From: Martyn White
Sent: 29 October 2021 15:10
To: Maria Tomalova
Subject: RE: AB/102/21/DOC

From: Maria Tomalova [REDACTED]
Sent: 19 October 2021 13:35
To: Martyn White <Martyn.White@arun.gov.uk>
Subject: AB/102/21/DOC

Project:-	Old Bank House 1 High Street Arundel West Sussex		
Title:-	Proposed Floor Plans		
Client:-	Moor Construction Ltd		
Scale:-	1:50 (@A1)		
Drawn By:-	PJD	Checked By:-	
Date:-	12/02/21	Date:-	
Job.No:-	200042	Drg.No:-	104

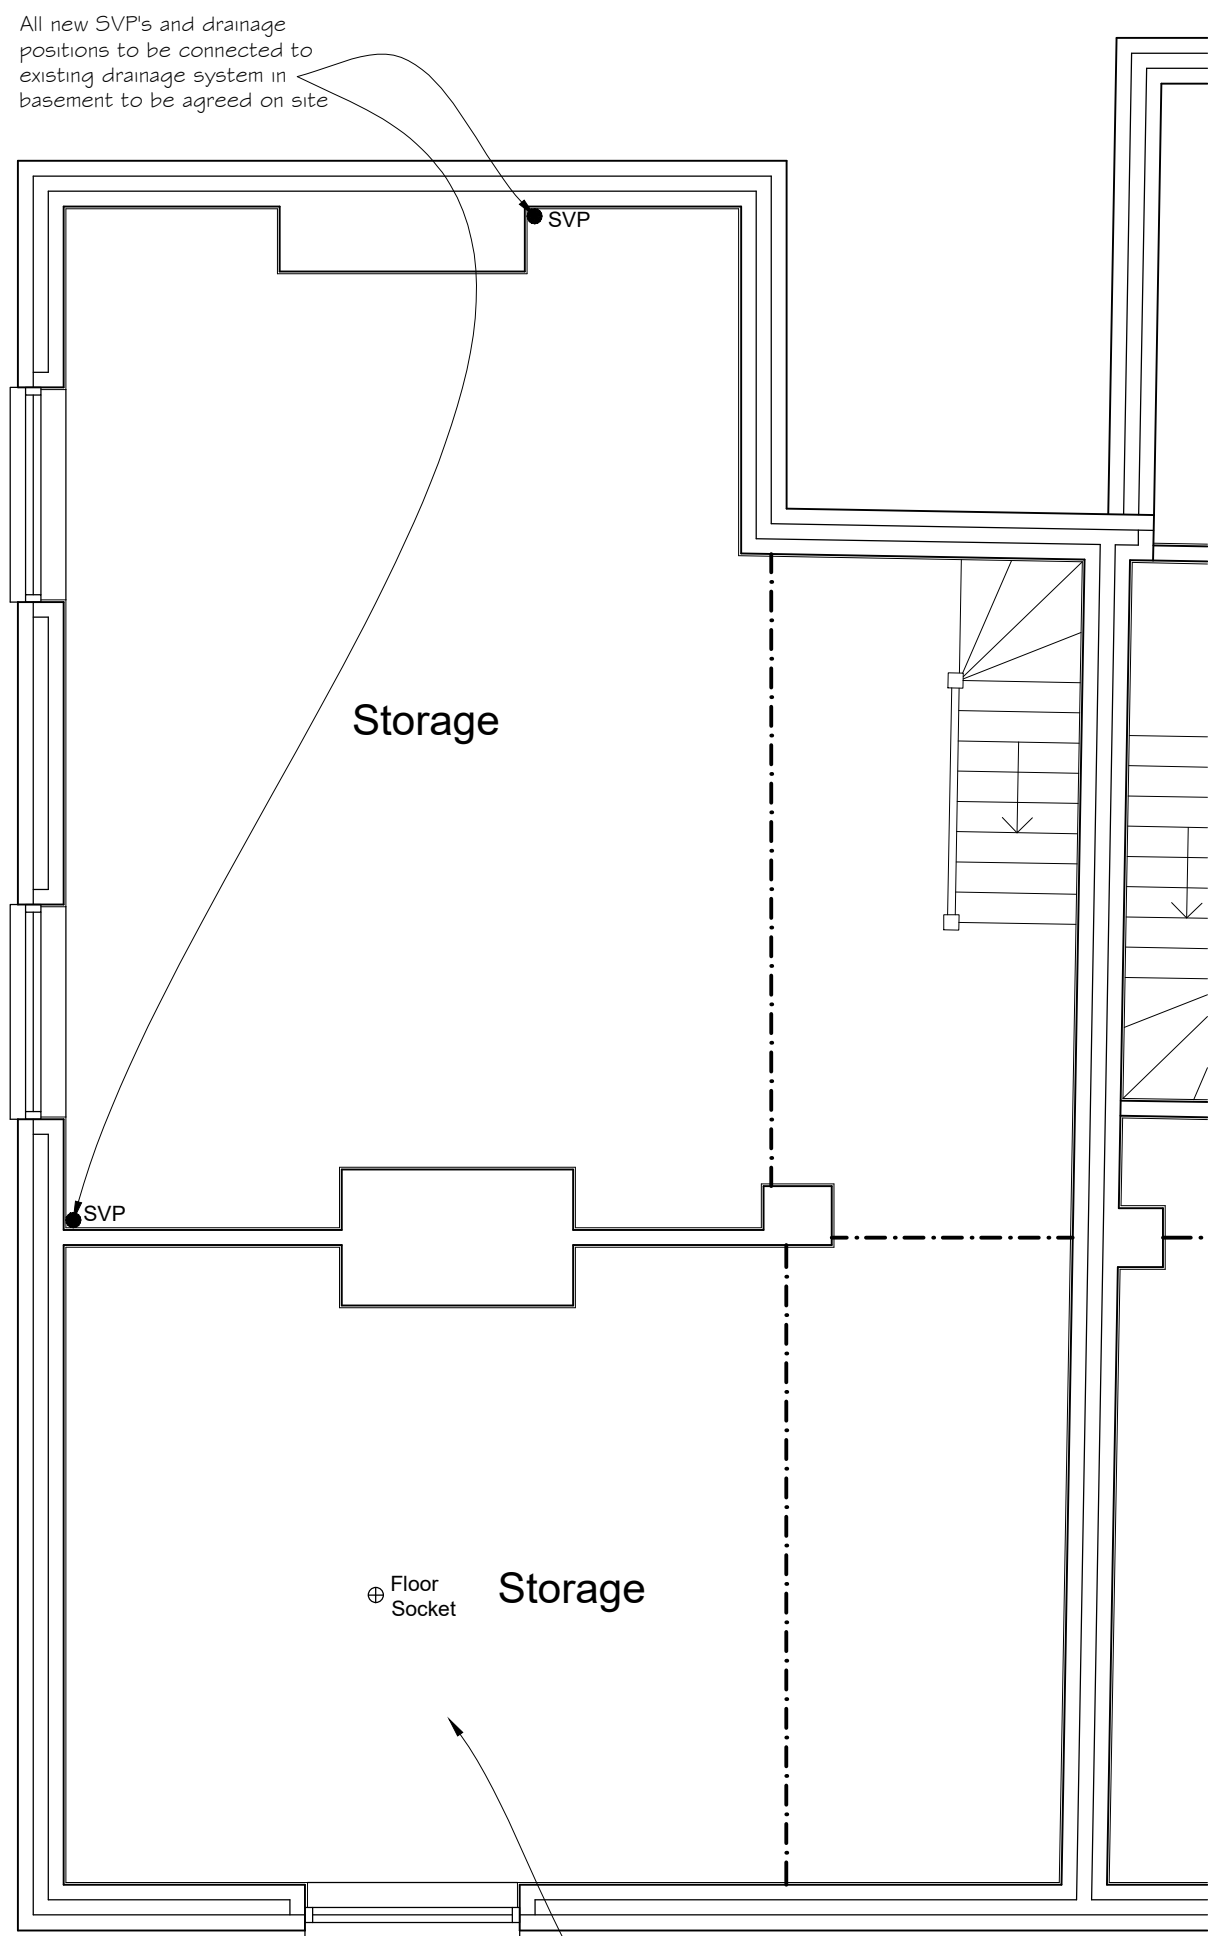
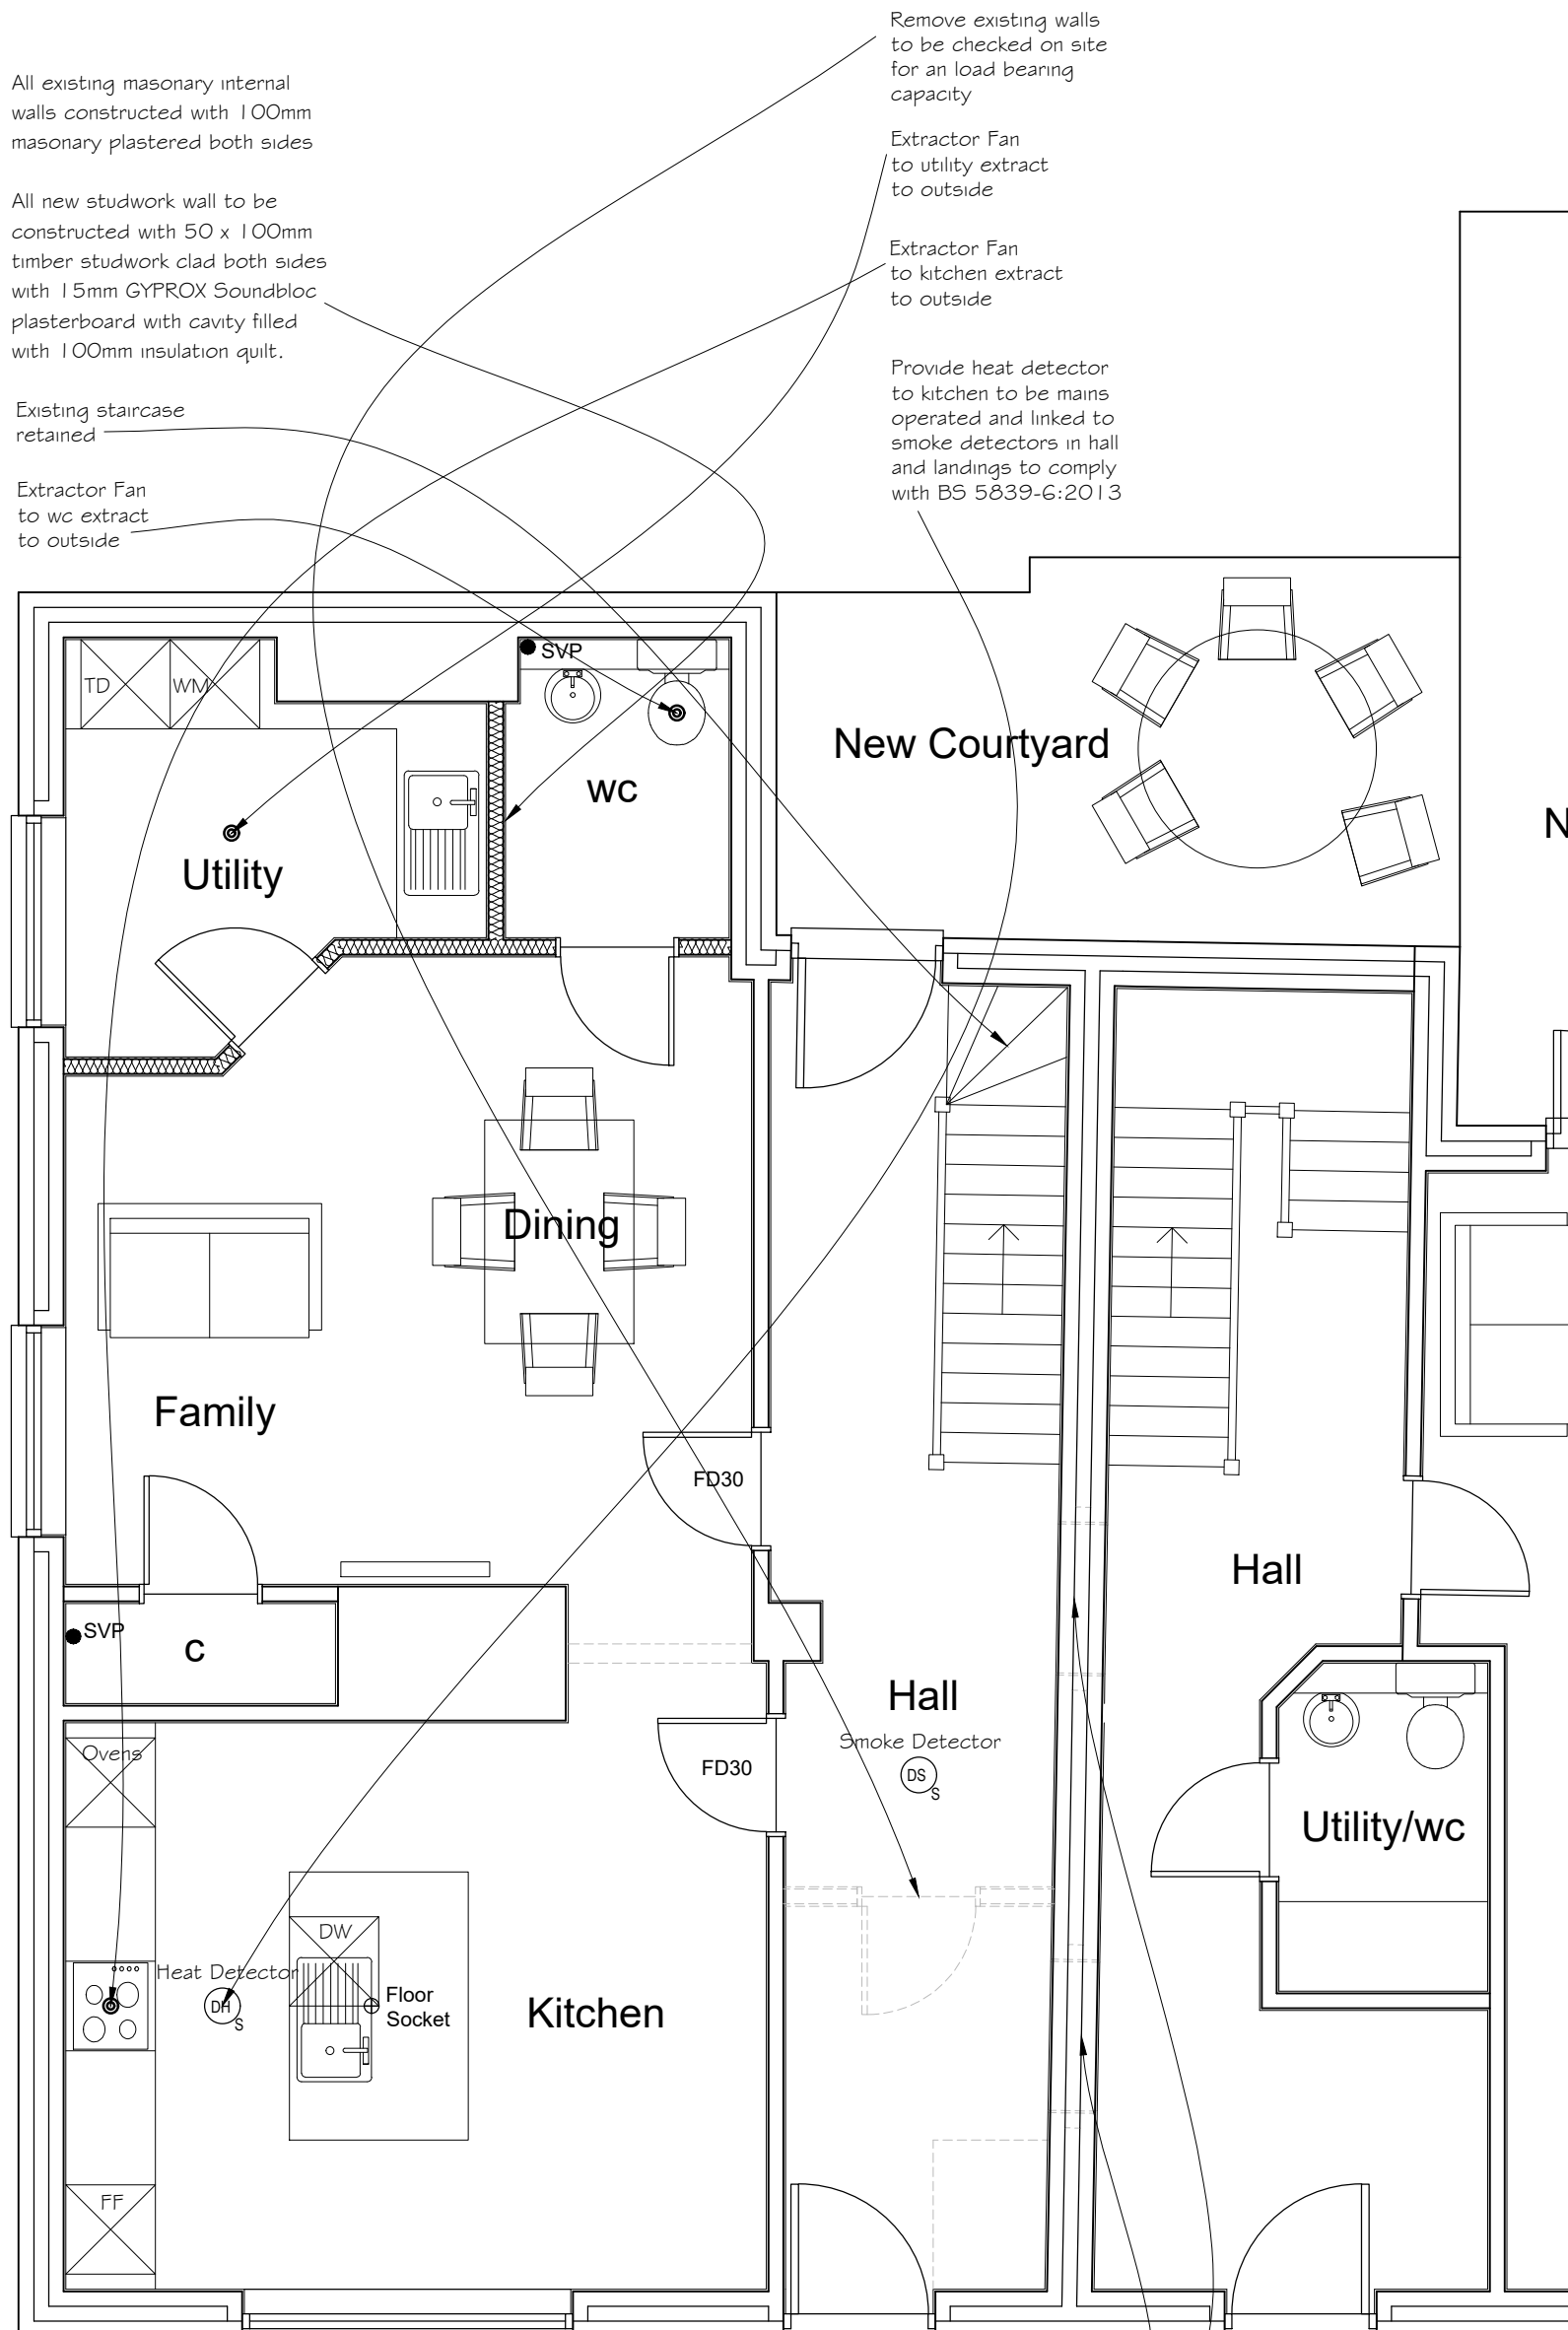
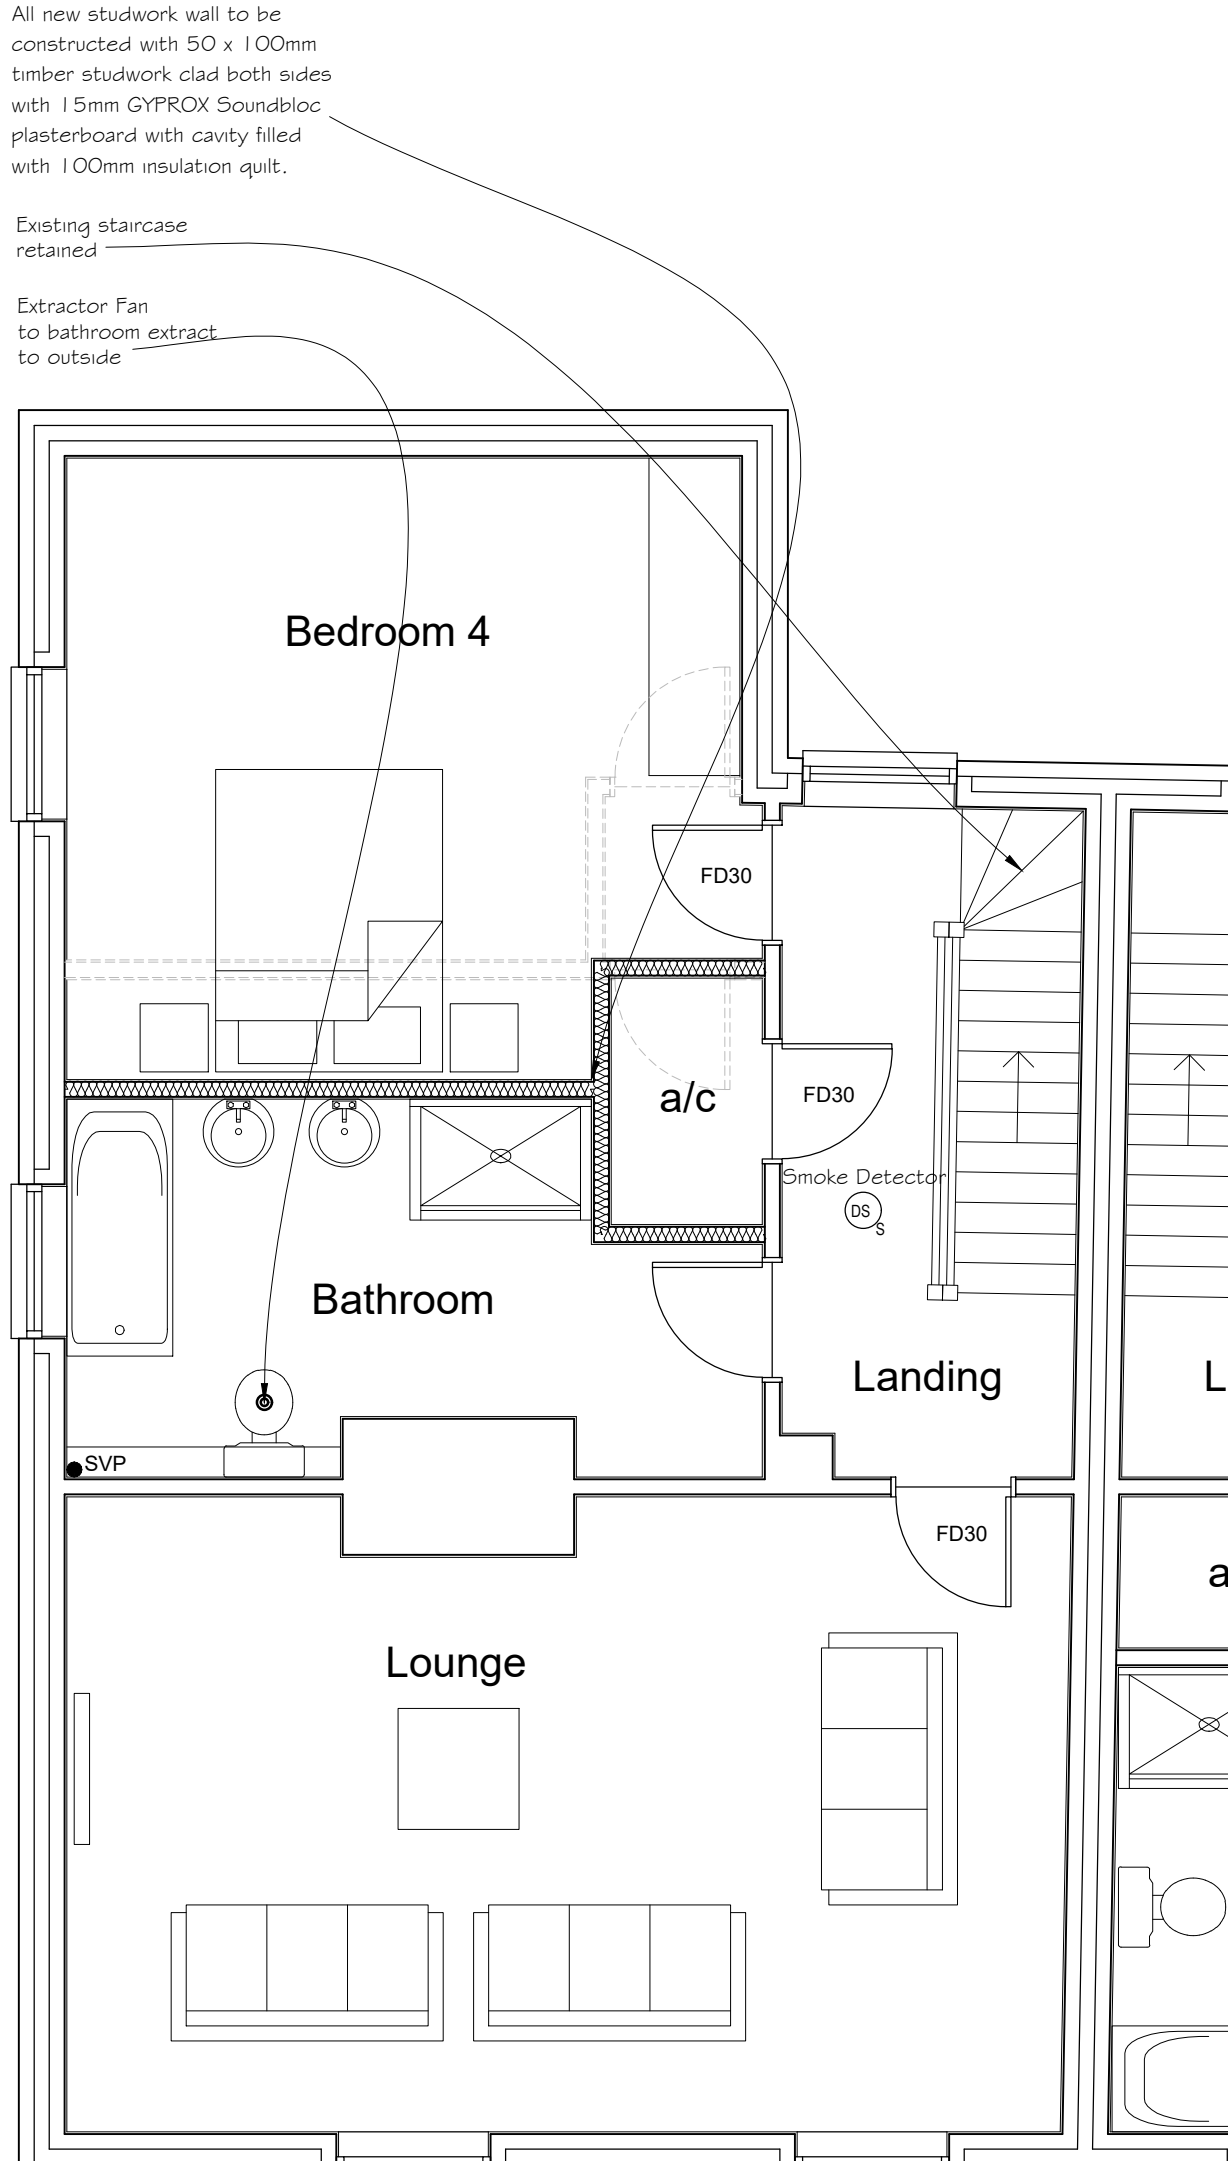
The air vent seems to be acceptable

I am sure that the doors will be ok, especially if they fit the existing openings and that they will be painted to as to look appropriate for the age and character of the building

'We would like to use a single cast iron conservation air vent. Please see link. <https://www.castironairbricks.co.uk/product/conservation-vent-grille/>

To confirm the existing door openings are in imperial sizes which would be 2 foot 6 inches. These can be purchased from our supplies. We do not intend to alter any of the existing door openings. We can purchase doors to fit. We propose to fit colonial 6 panel fire doors to match the existing front door.'
